Markup Summary

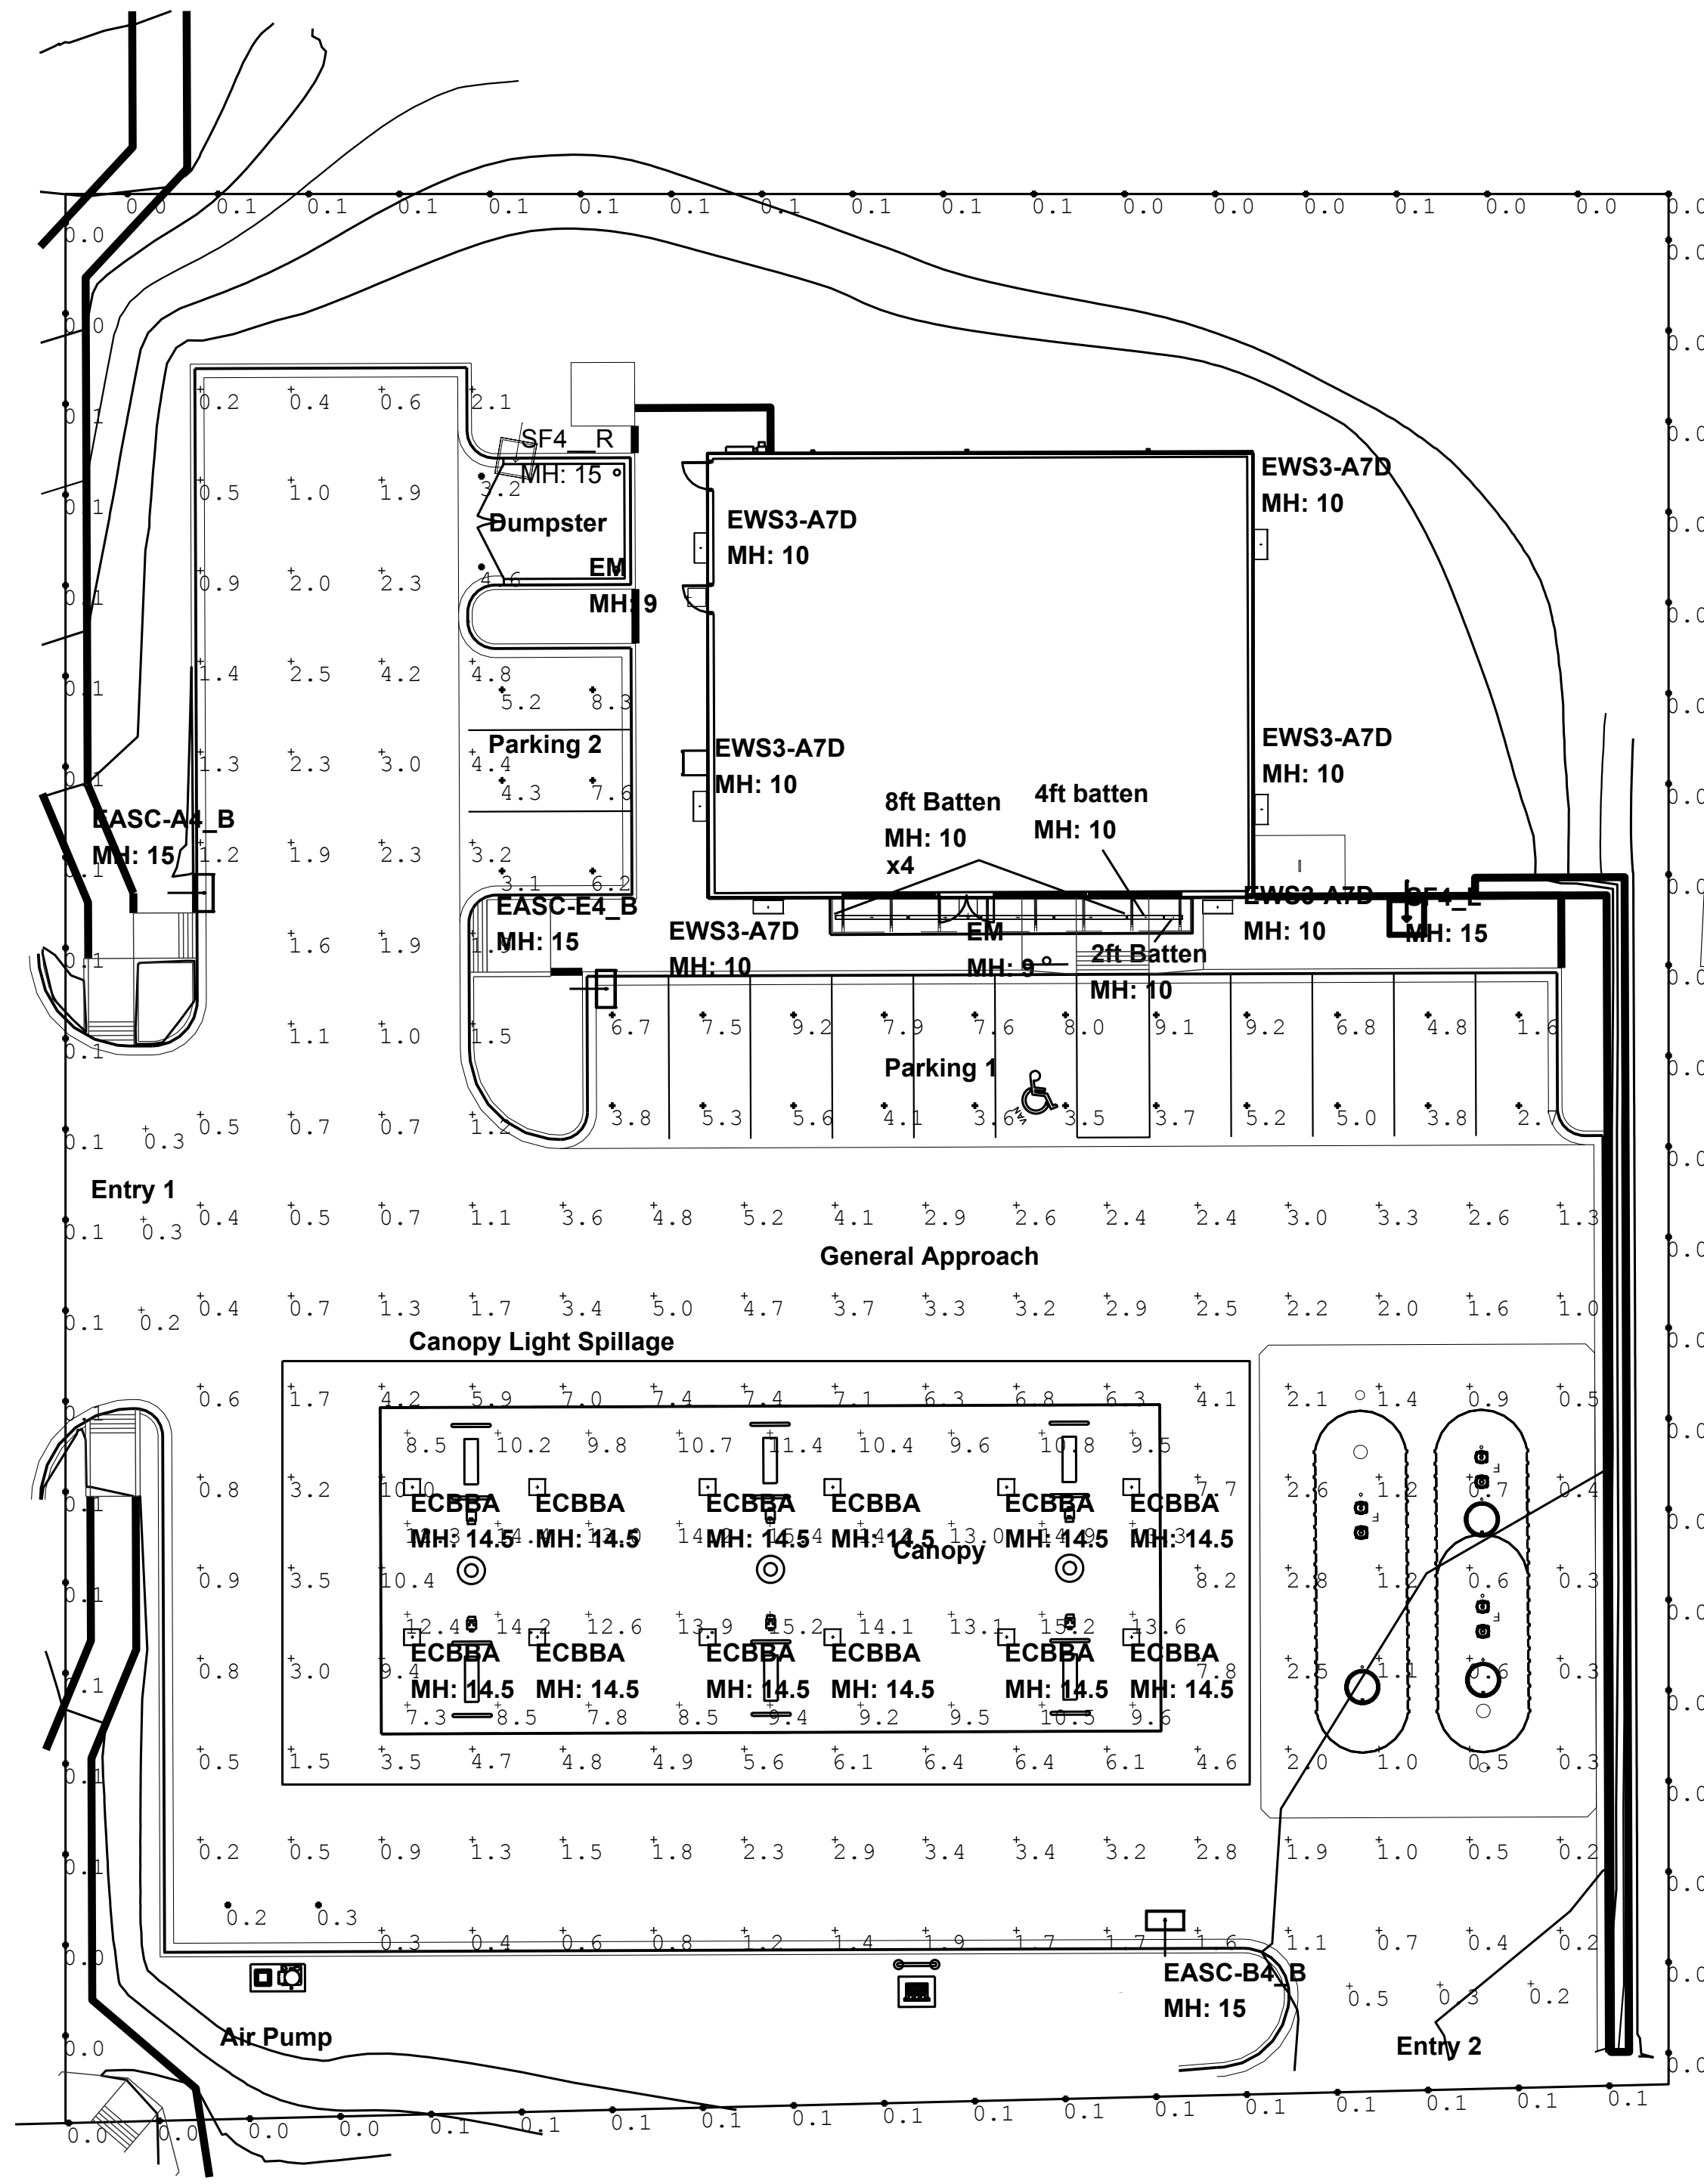
15' distance from Prop line required to avoid IES Type II or Type III

entry lighting location not parking

0.1 is the allowance at the property lines

20 foot candles is the maximum allowed under canopy. page 6-18

what is height of the wall lighting? 10' is max height

Maximum on site lighting should not exceed 10 foot candles, except for loading areas where it page 6-17

15' is the max height unless in parking lot.

Identify all property lines and show lumens at all prop lines. 0.1 is the allowance for max foot candles in the Code. Adjust the light fixtures to achieve this Code standard. Page 6-17
